From: Amanda Scholes on behalf of Planning.Responses
Sent: 08 June 2020 11:50
To: Planning Scanning
Subject: FW: 2020-05-15-19163-PARCELS A2 & B6, Littlehampton - Drainage Drawings

Comments;

Subject: 2020-05-15-19163-PARCELS A2 & B6, Littlehampton - Drainage Drawings

Flow Control Chamber HB1

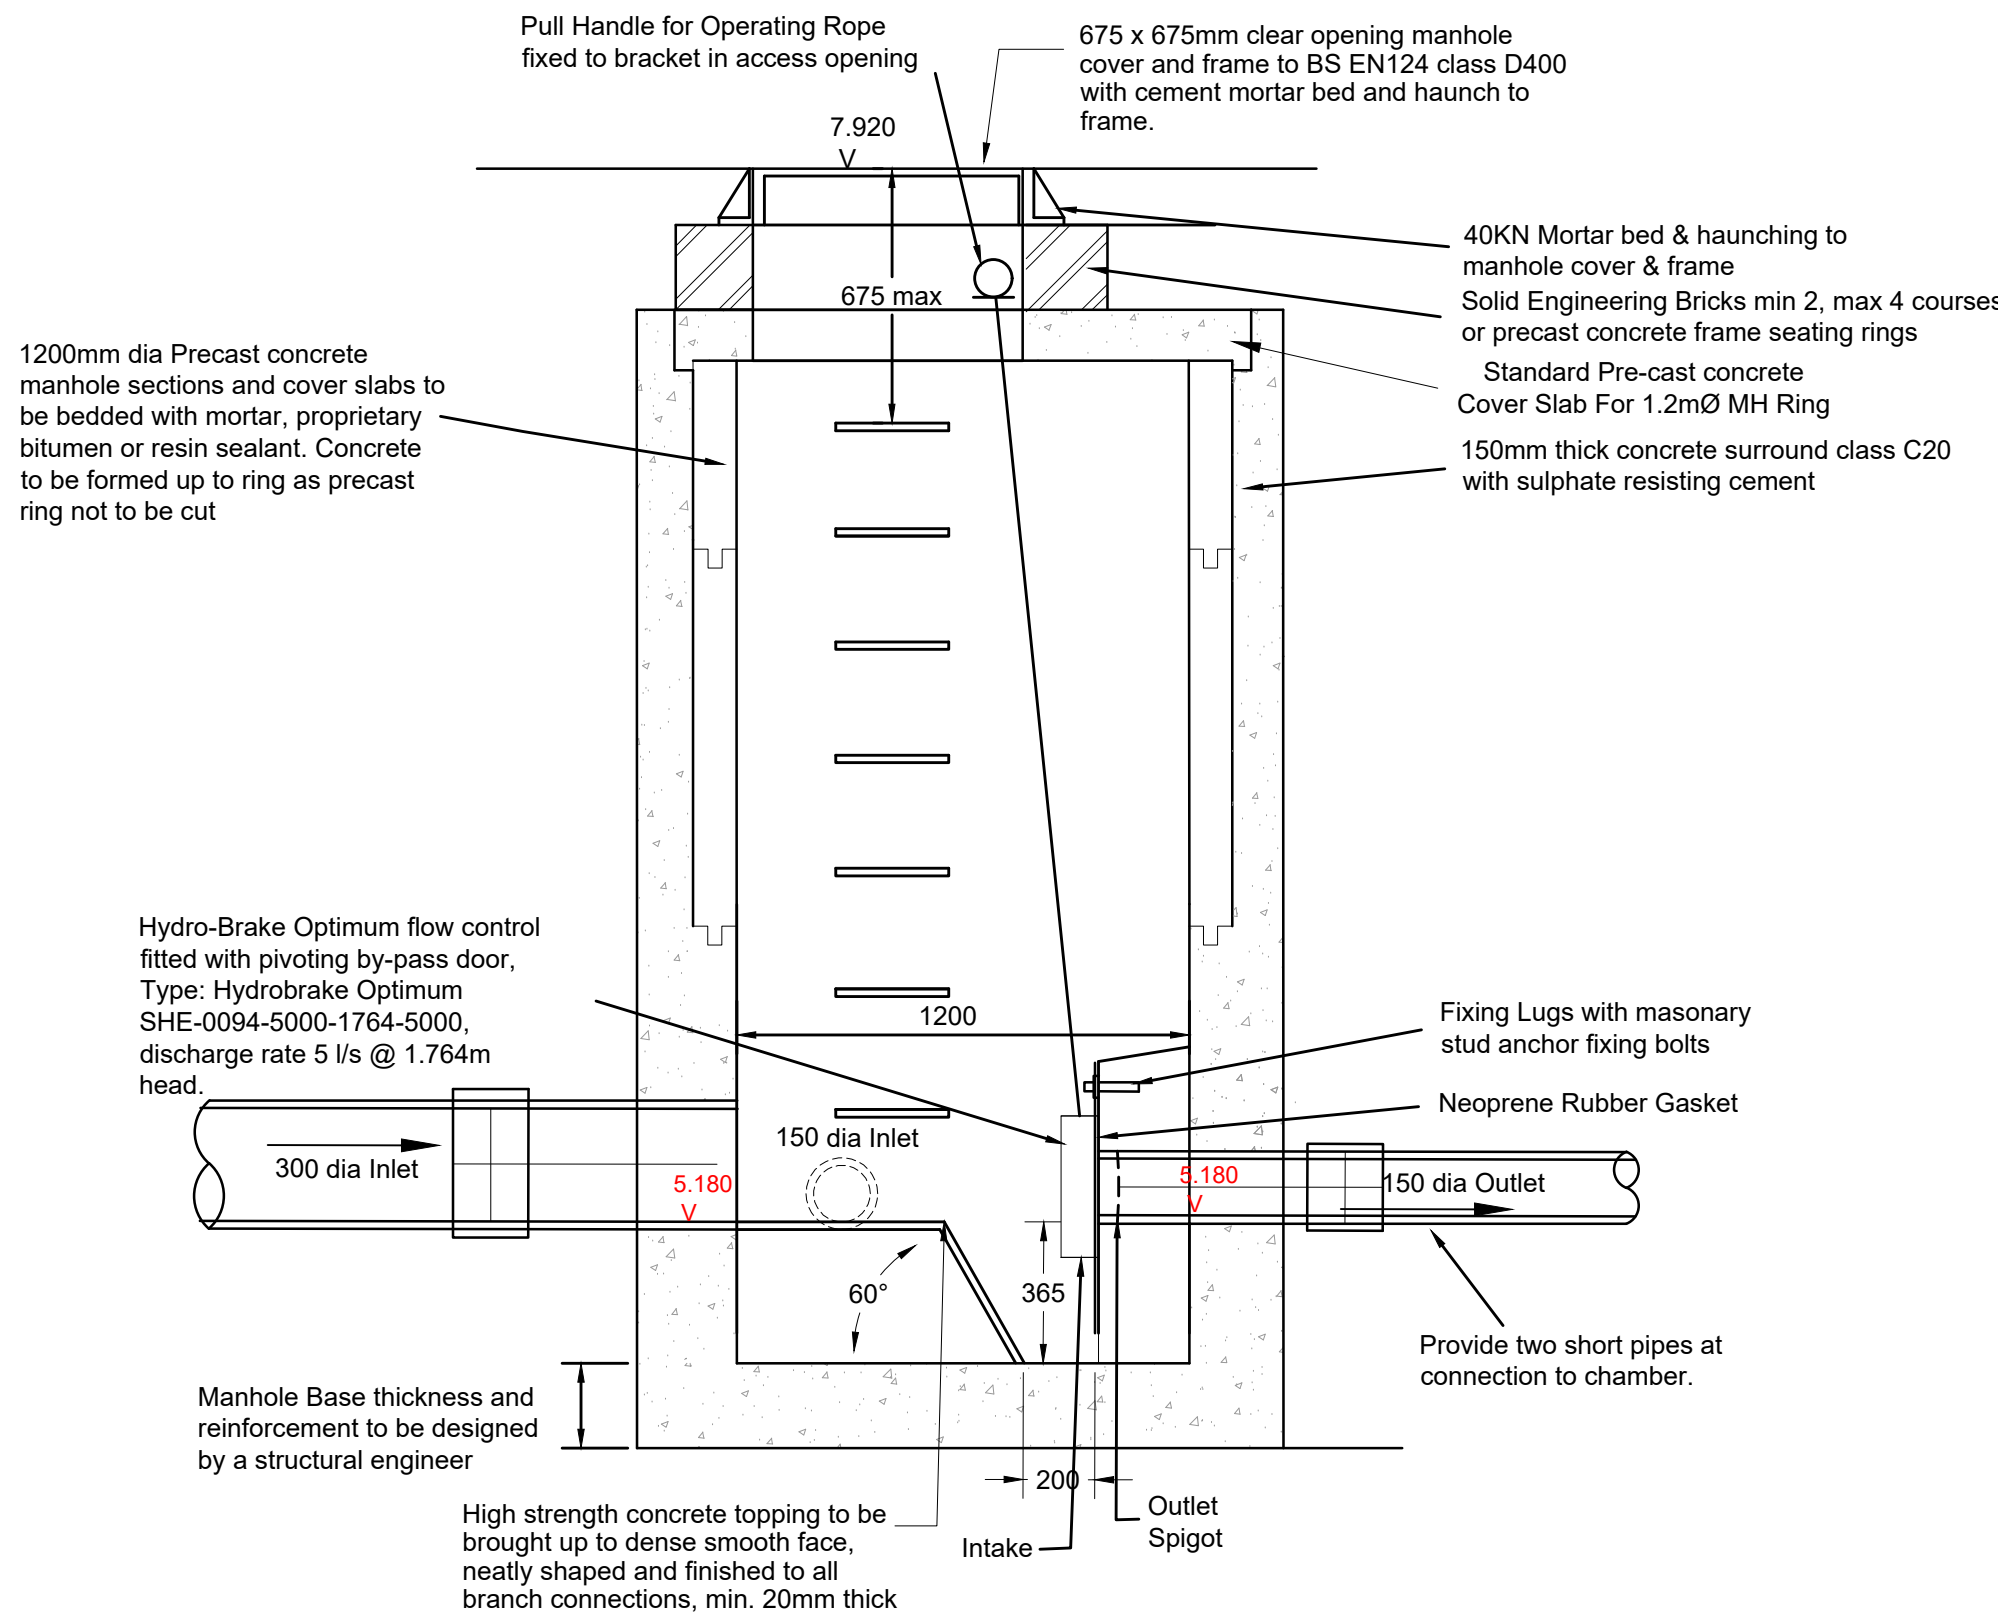
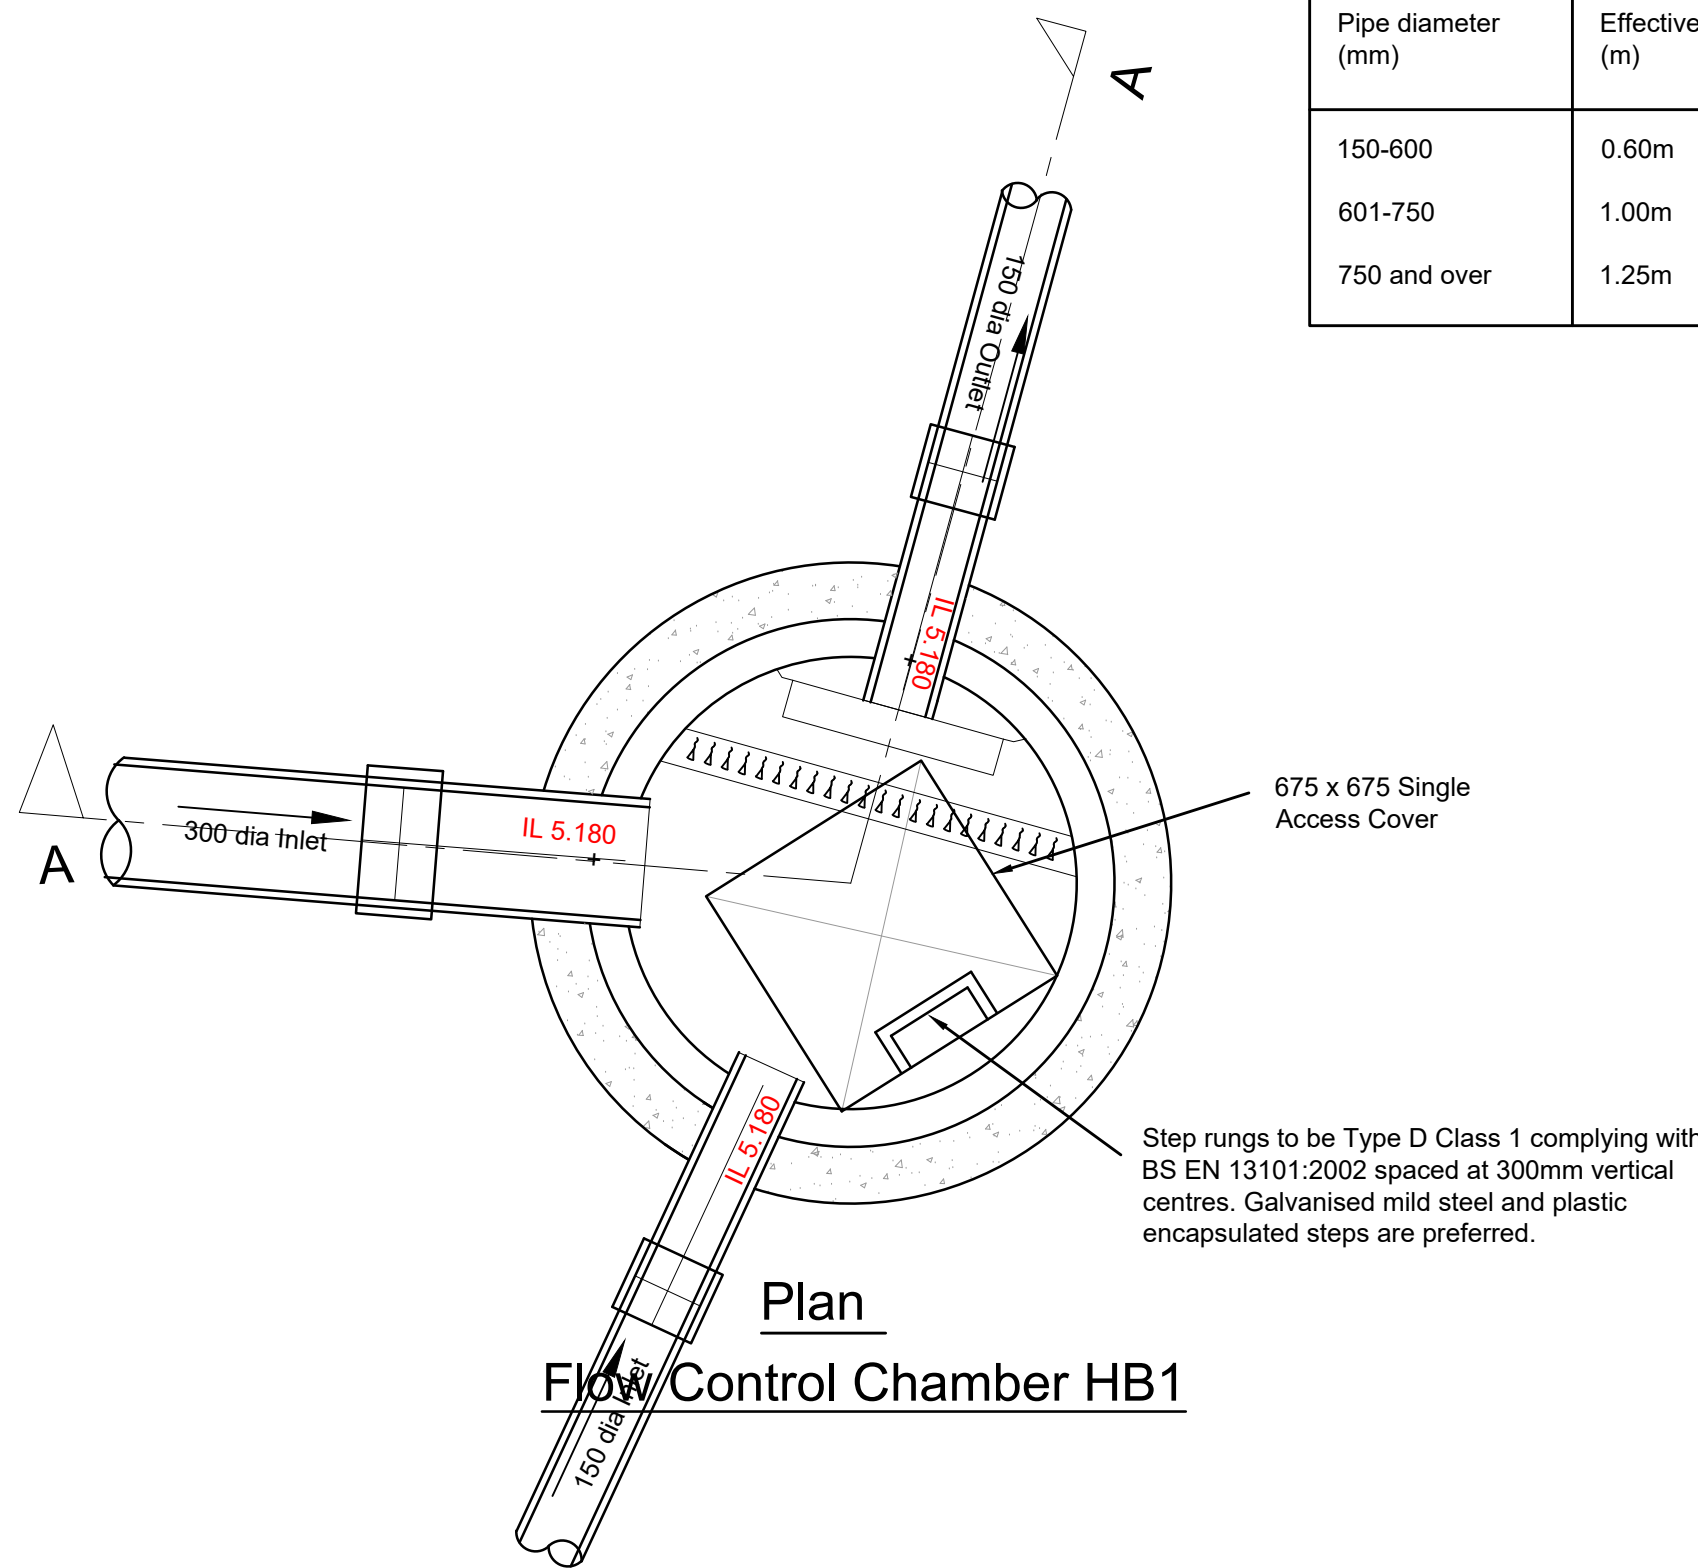
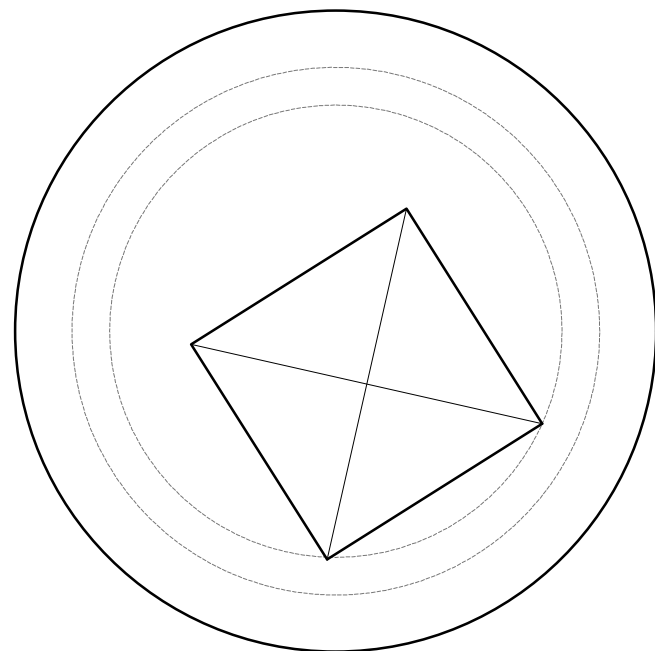
3. Provide channel drain construction details/spec. *ok*
4. Hydrobrake chamber HB01 construction detail – connect incoming 150mm connection from permeable paving at soffit to soffit level with 300mm pipe inlet. *ok*

6. Both hydrobrake chambers – show base thickness/reinforcement details. *ok*
7. Existing manhole SW03A – just upstream of SWA2_01 – what is its purpose? Invert level is lower than the downstream manhole. Please clarify if it is required and adjust as necessary. *Removed - ok*
